From: Amanda Scholes on behalf of Planning.Responses
Sent: 24 September 2018 09:00
To: Planning Scanning
Subject: FW: A/111/18/DOC

From: Emma Patchell [REDACTED]
Sent: 31 July 2018 10:35
To: Juan Baeza
Cc: Neil Crowther
Subject: FW: URGENT - RE: A/23/18/DOC - Broadlees, Dappers Lane, Angmering

From: Emma Patchell [REDACTED]
Date: 23 July 2018 at 16:37:51 BST
To: Juan Baeza [REDACTED]
Cc: Mark Warwick [REDACTED], Neil Crowther [REDACTED]
" [REDACTED] Anna Gillings
[REDACTED]
Subject: RE: URGENT - RE: A/23/18/DOC - Broadlees, Dappers Lane, Angmering

From: Anna Gillings
Sent: 20 July 2018 09:43
To: Juan Baeza <[REDACTED]>
Cc: Timothy Bloomfield [REDACTED]; Mark Warwick
<[REDACTED]> Emma Patchell <[REDACTED]> Neil Crowther
[REDACTED]
Subject: URGENT - RE: A/23/18/DOC - Broadlees, Dappers Lane, Angmering

TREE PROTECTION (Plan 3A)

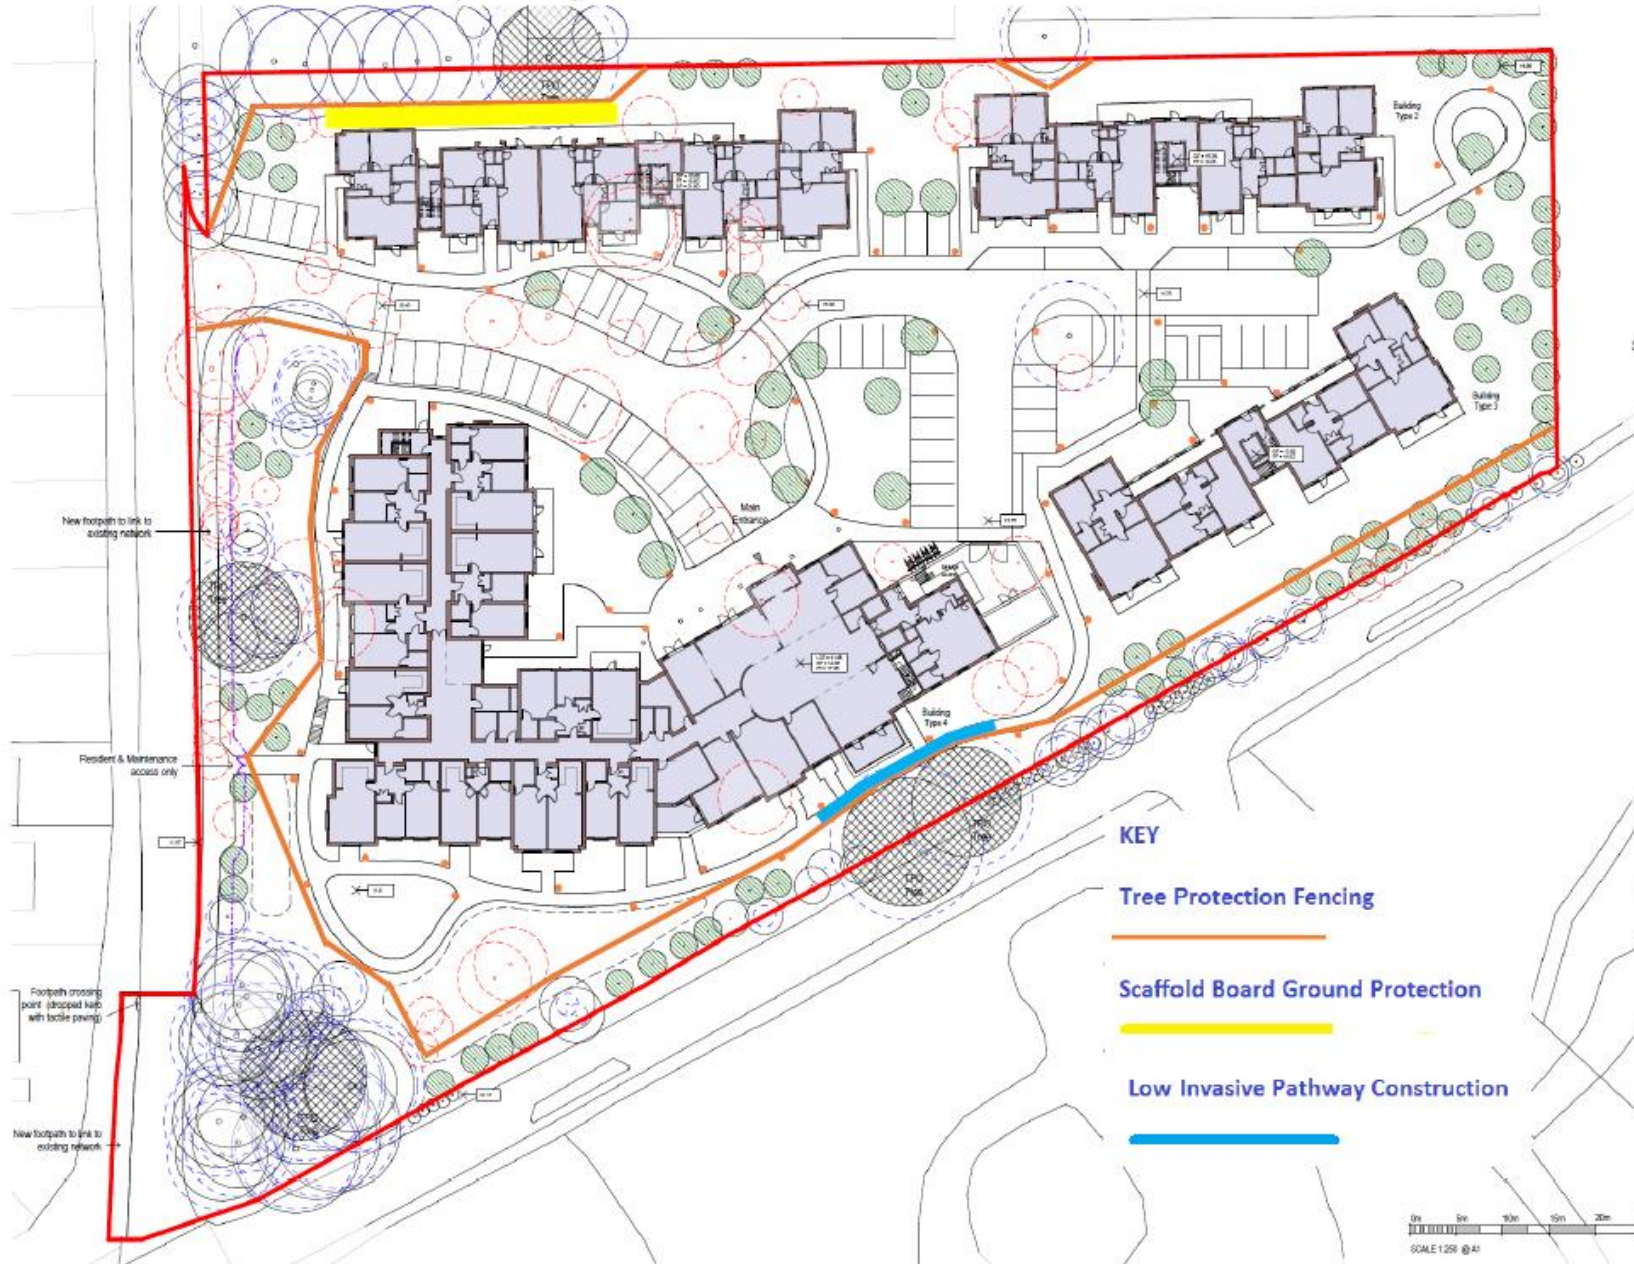
The provision (and subsequent agreement by the LPA) of a suitable Tree Protection Plan (TPP) is not of itself sufficient to discharge the condition. This has always been MY approach and one I am familiar with having been followed by experienced practitioners of BS5837:2012.

Any tree protection measures must be in place before heavy plant access, soil movement, demolition or construction occurs. The prior installation of an effective 'Construction Exclusion Zone' and any specified ground protection measures must be inspected by and be to the satisfaction of the LPA (Tree Officer) before the appropriate condition can be discharged. Anything less and we are facilitating the occurrence of potentially irreversible damage to those trees identified for retention.

“ This site is overgrown and in a wild and impenetrable state with dense vegetation surrounding many of the trees that are to be retained.

At the present time NO vegetation clearance has taken place and NO protective fencing has been erected.

In the absence of general vegetation clearance and erection of Protective Fencing the Condition has not been complied with and I am therefore unable to sign it off at this time.

I note that the applicant has submitted a Tree Protection Plan Ref: Plan 3A – the measures set out on this plan are acceptable but will need to be implemented and then a Pre-Commencement Meeting can take place [at a mutually convenient time] between the applicants representative and the Arun DC Tree Officer to agree that the Protective Fencing complies with BS5837 recommendations and is 'Fit For Purpose' and that it has been erected exactly as shown on Plan 3A".

Tree protection – we had agreed that the condition would remain live until Mark had inspected the works (as per your email below). I advised the measures are going up next week, in accordance with the agreed plan. Hence, there was no justification for a refusal.

Once those measures are in place, I would be happy to make a prompt inspection and then hopefully be in a position to promptly 'sign off' their application for a DOC.
